DISAPPROVED
Plan Review
03/19/2021 9:01:32 AM
dsdrangel
EPC Planning & Community
Development Department

TAX SCHEDULE NO: 5123000049
LOT AREA: 10 Acres

AG2115
RR-5
CD 11/6/89

TAX SCHEDULE NO: 5123000049  
 LOT AREA: 10 ACRES

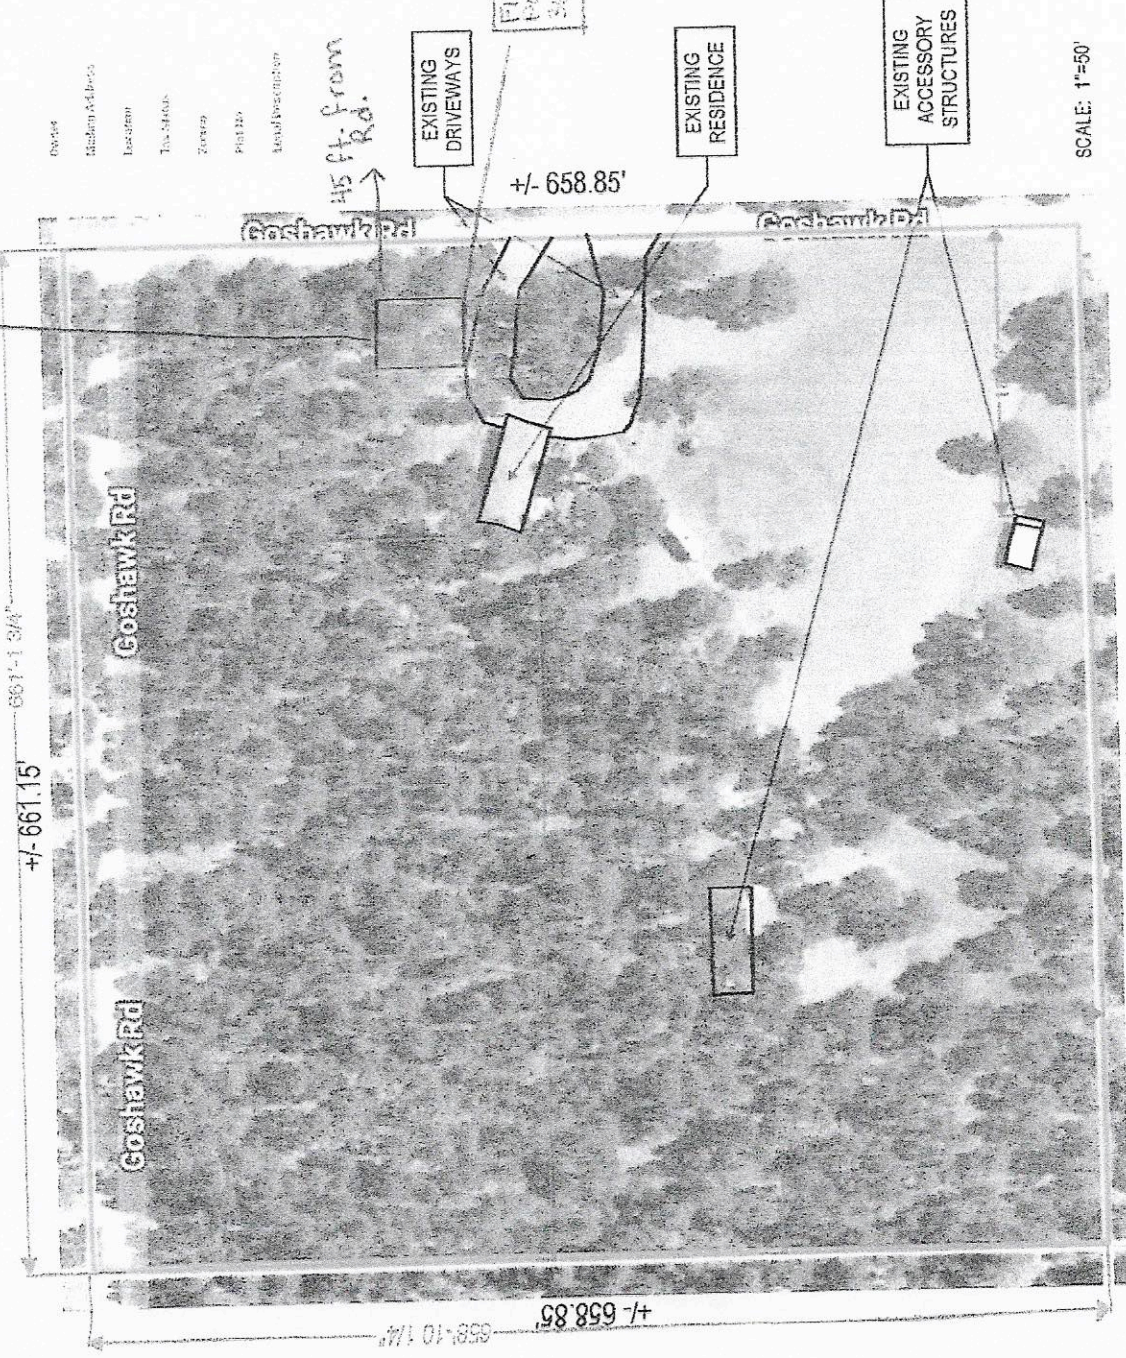
Provide these two distance measurements

Applicant must reach out to the planner of the day prior to resubmission. Creation date of the parcel is 11/6/89 which indicates the parcel was illegally created. The planner can verify if this is the case or if we have record showing it is a legal non-conforming lot.
